Consultation Response from KC, Highways Development Management
2024/92504 134, Birkby Hall Road, Birkby, Huddersfield, HD2 2UZ
Change of use from vehicle repair and sales to vehicular repair, sales and hand car wash with associated works (within a Conservation Area)
Date Responded: 04/06/2025 Responding Officer: D. Stainsby Responding Ref: K5-6SE/11

Drawing Title:  
EXISTING AND PROPOSED PLAN.

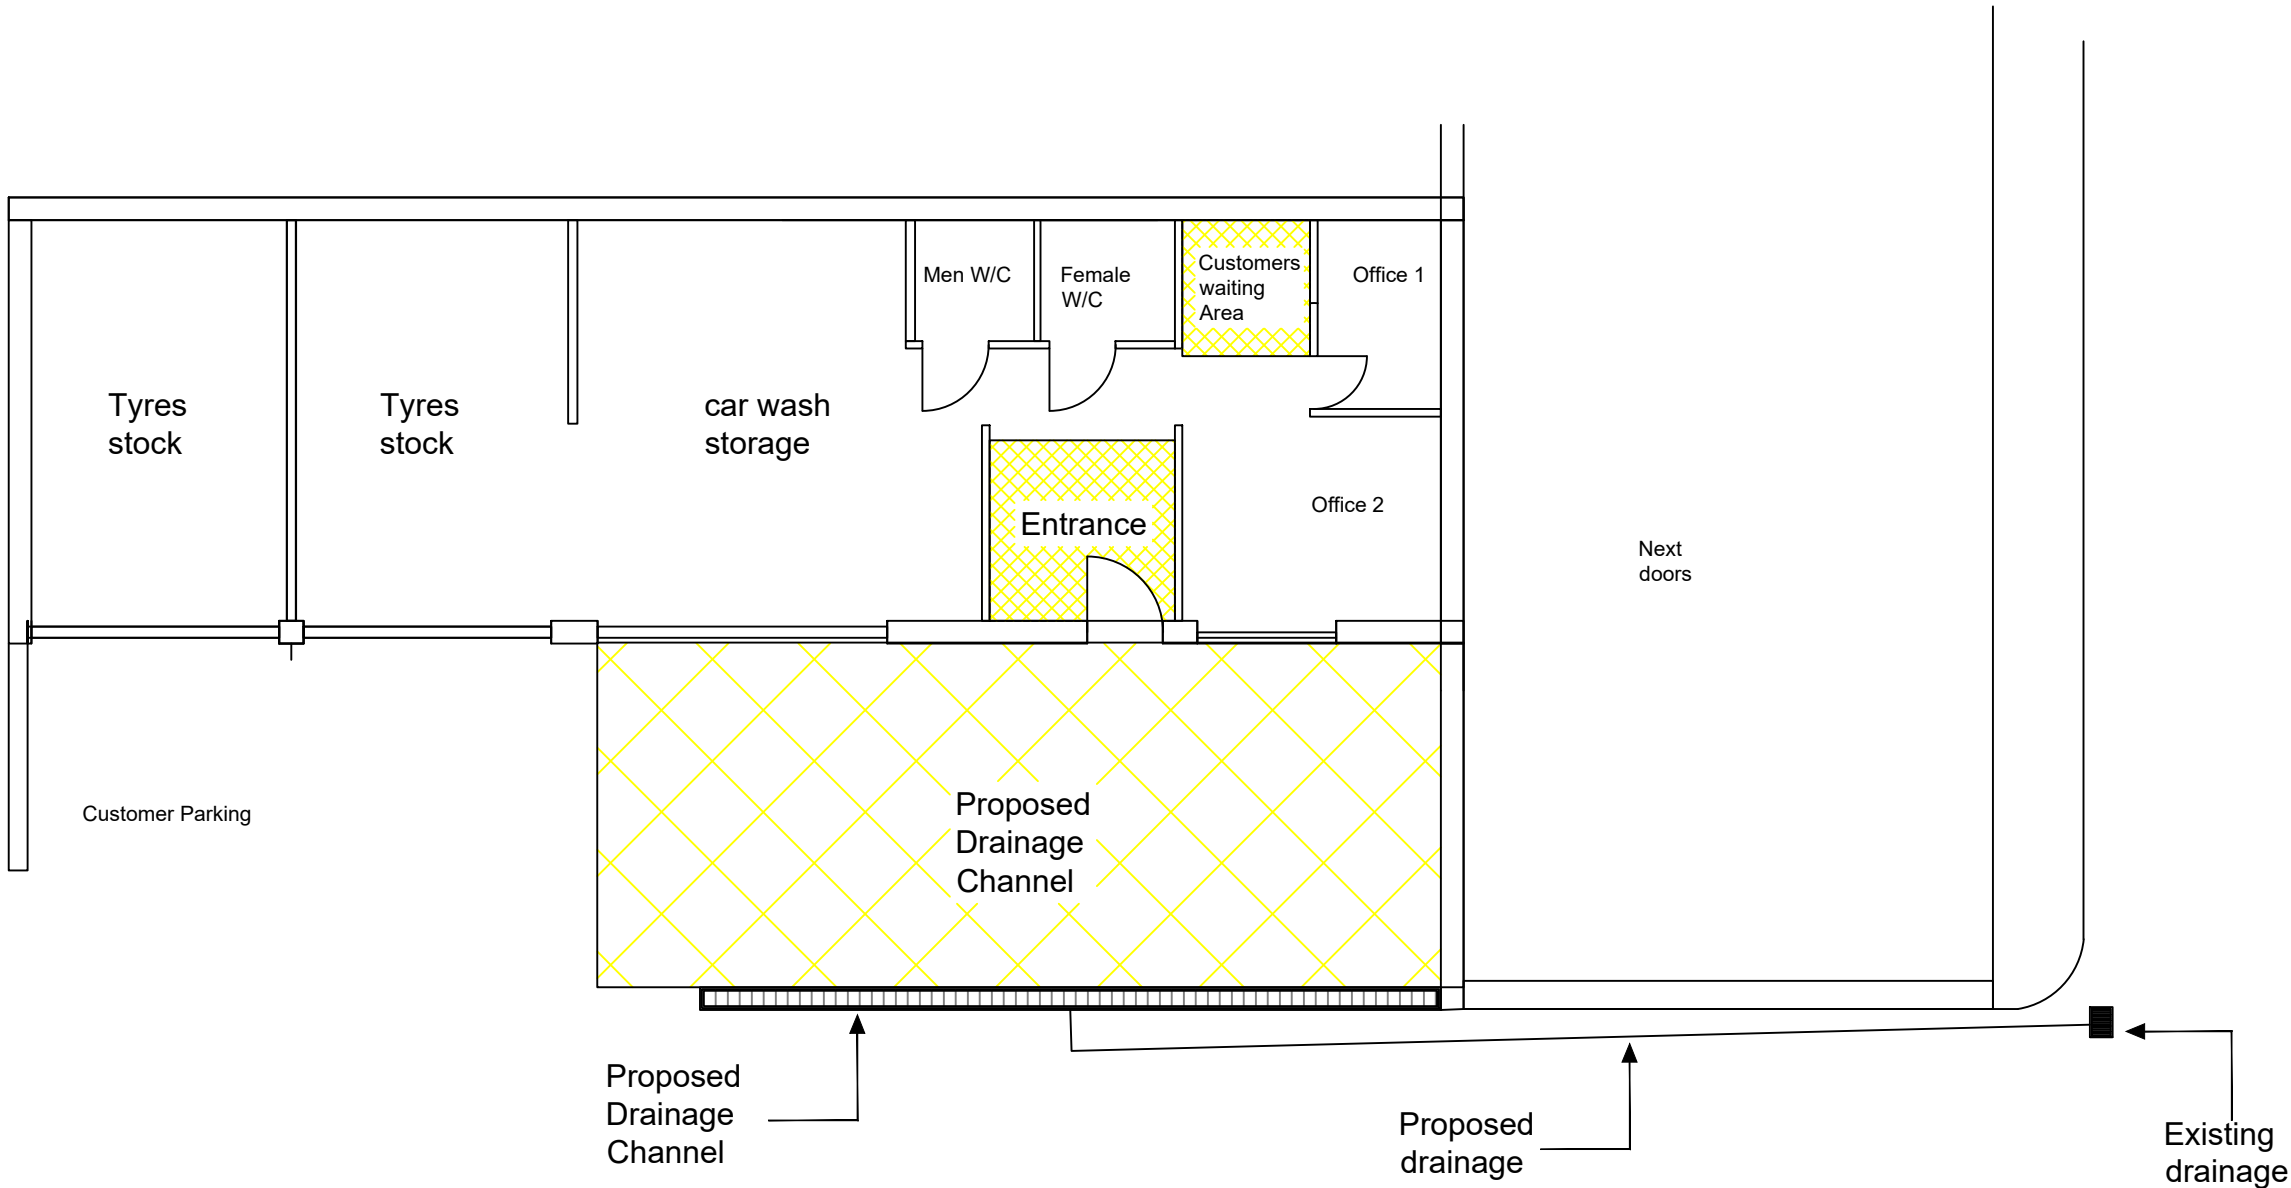
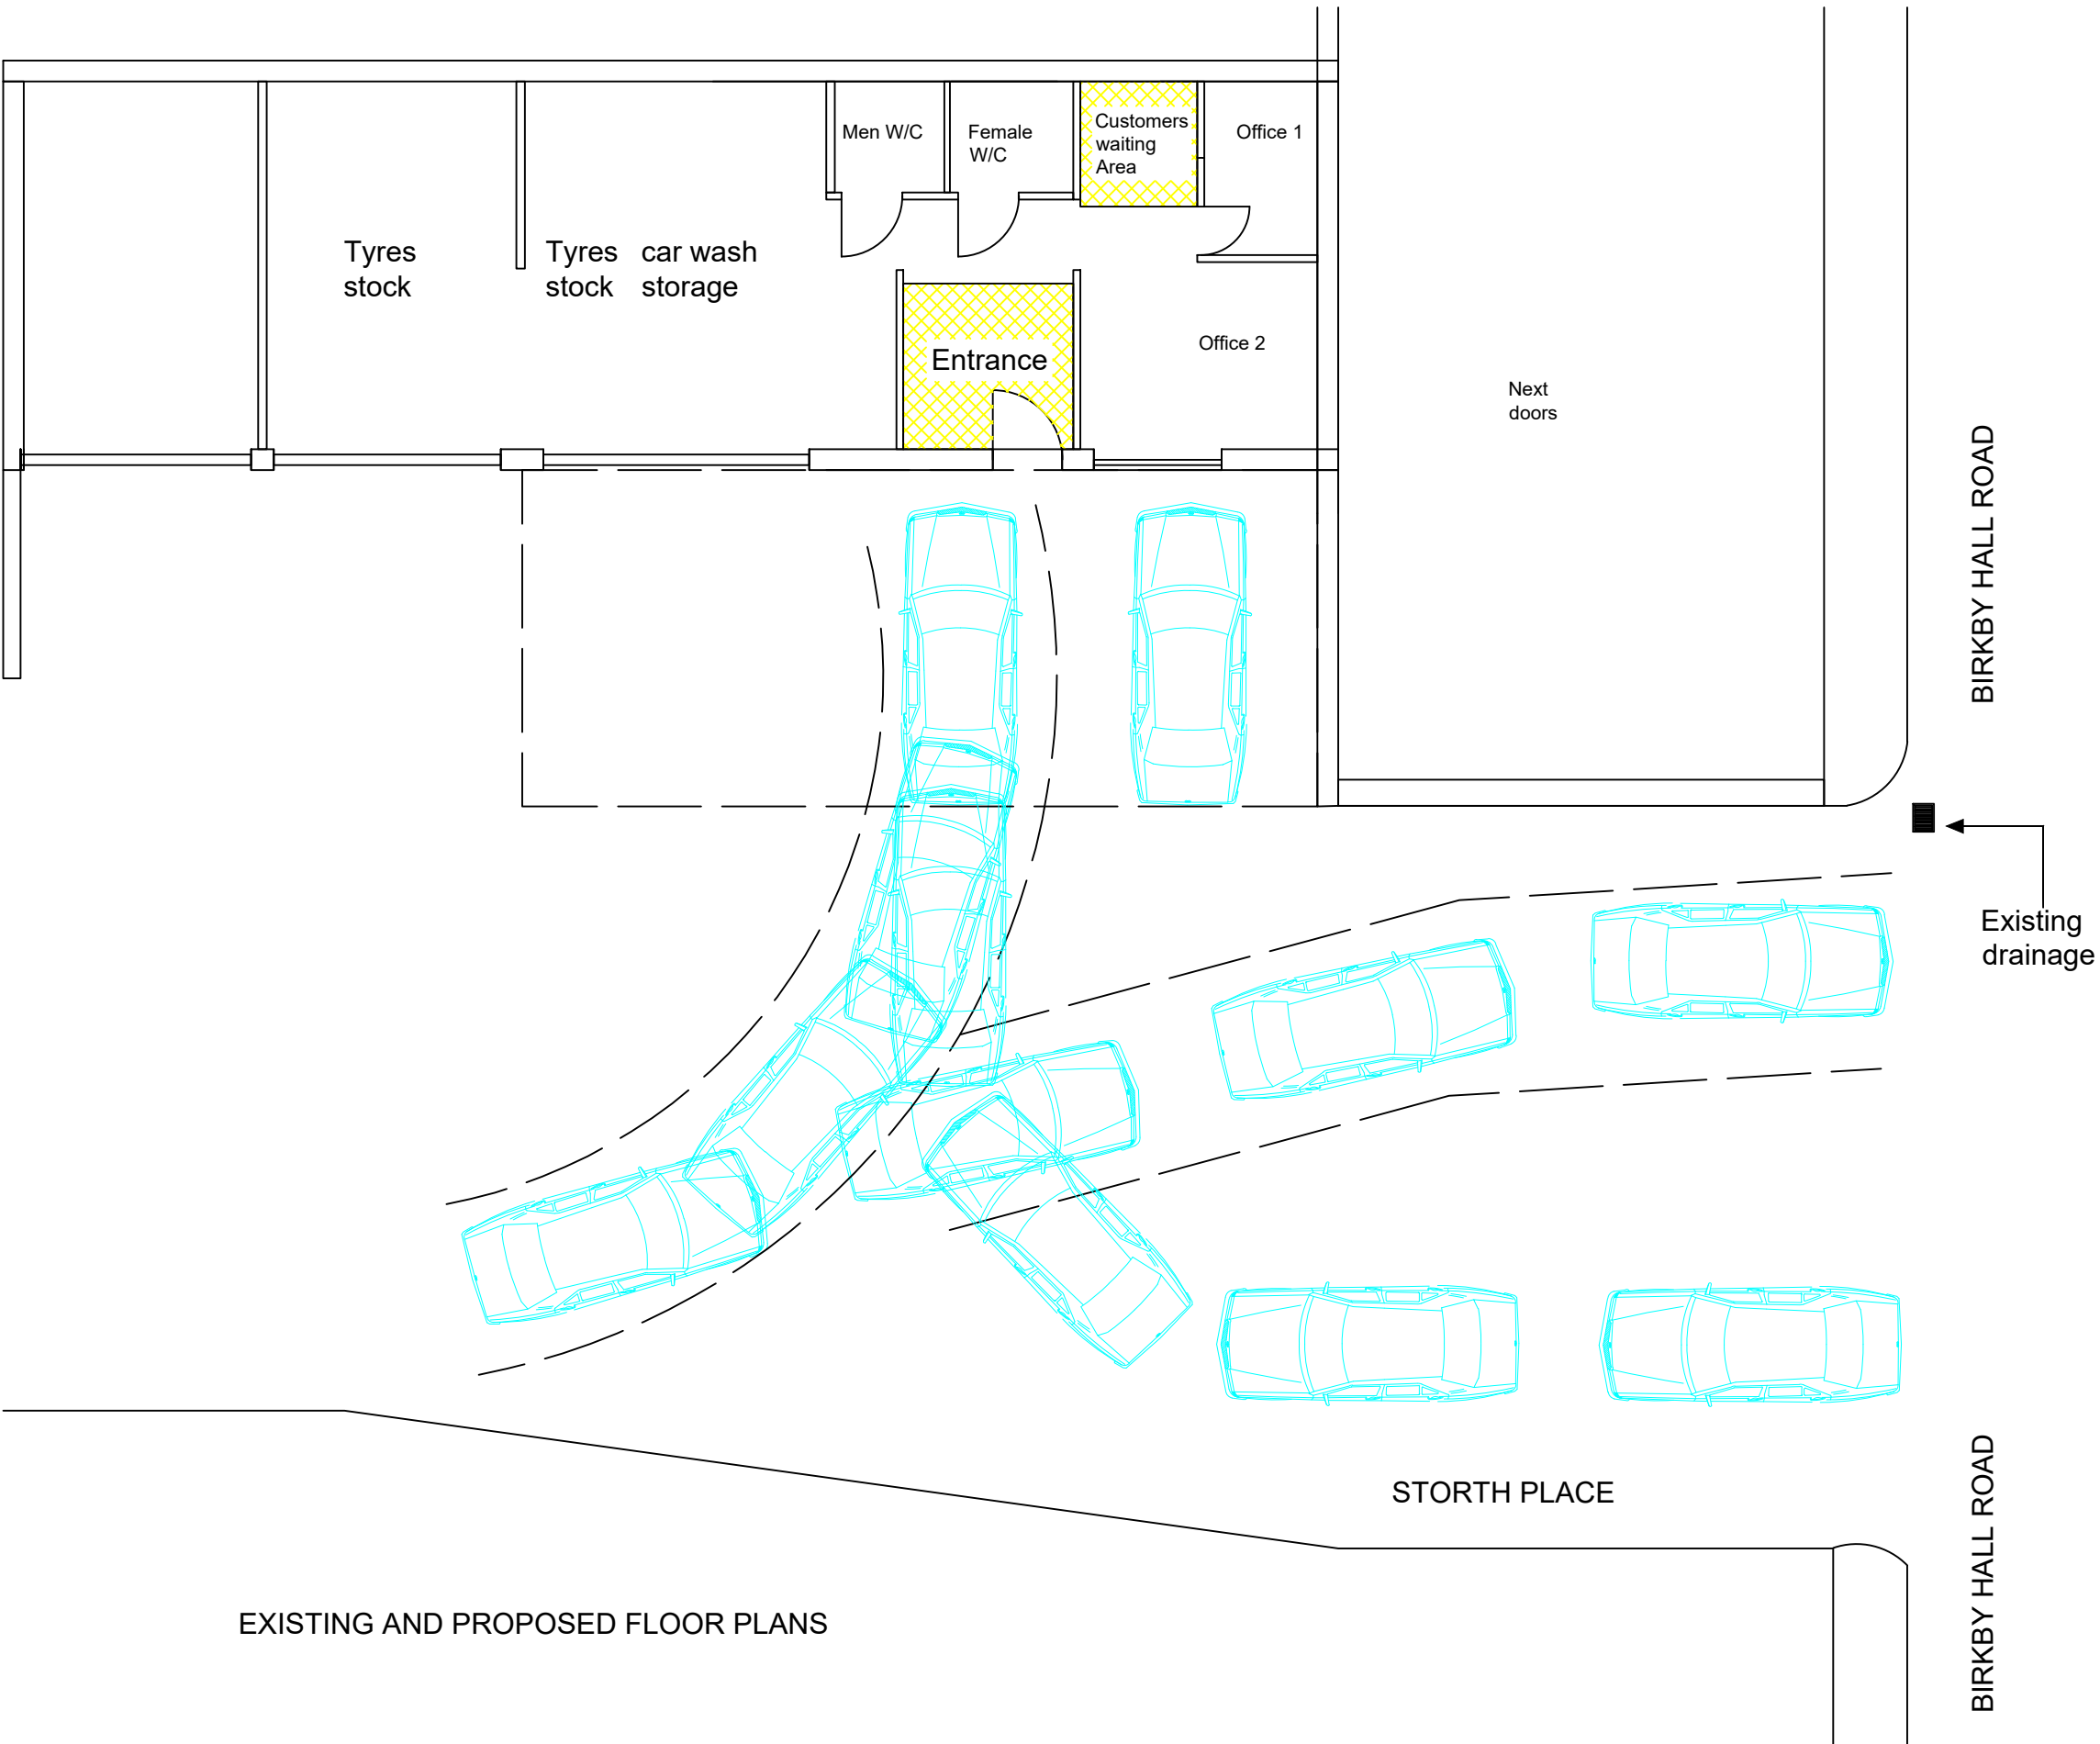
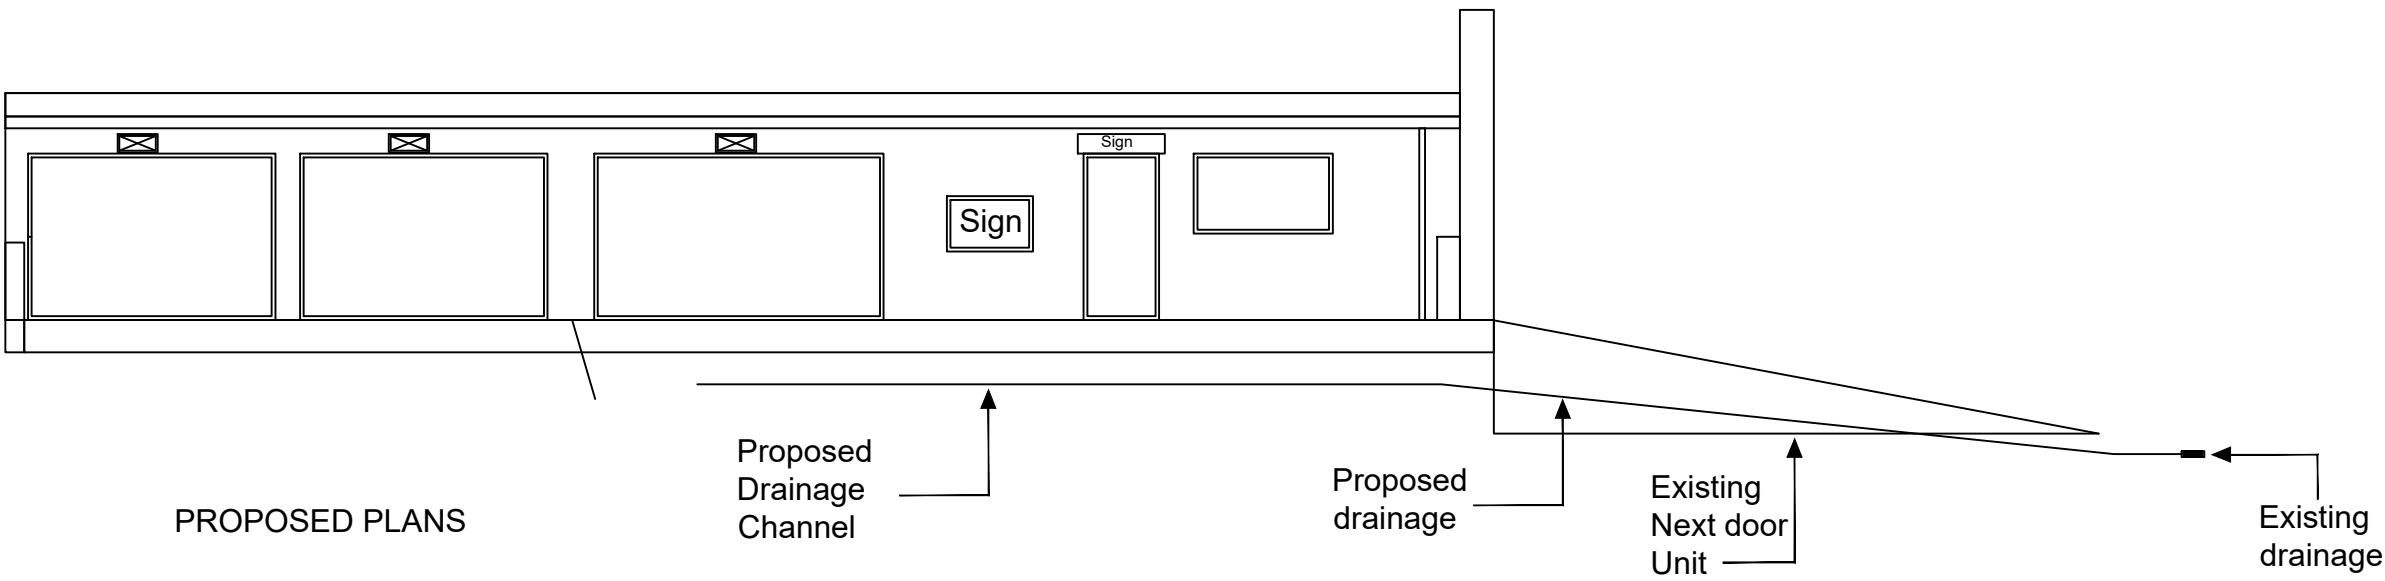
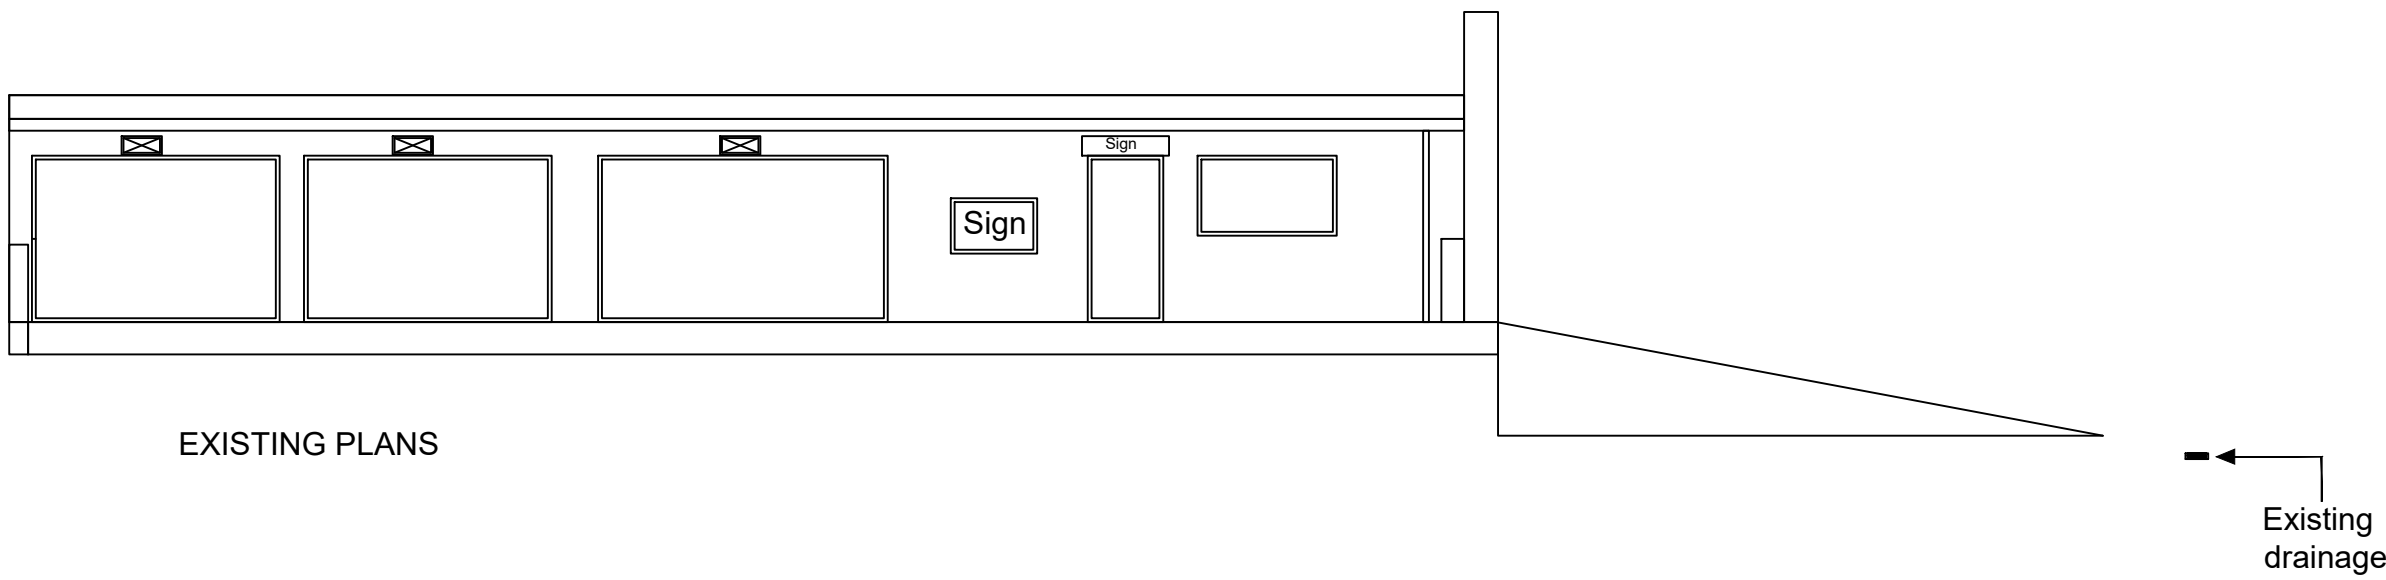
The original proposal was for the car wash area to be on the site forecourt which was considered to be an overdevelopment of the site. However, this proposal has been resubmitted so that the car wash area is within the garage and the forecourt used for waiting vehicles.

The Applicant has also stated that an appointment only system will be used which will regulate the number of vehicles on the site at any one time

As a result, the proposals are now acceptable to Highways DM
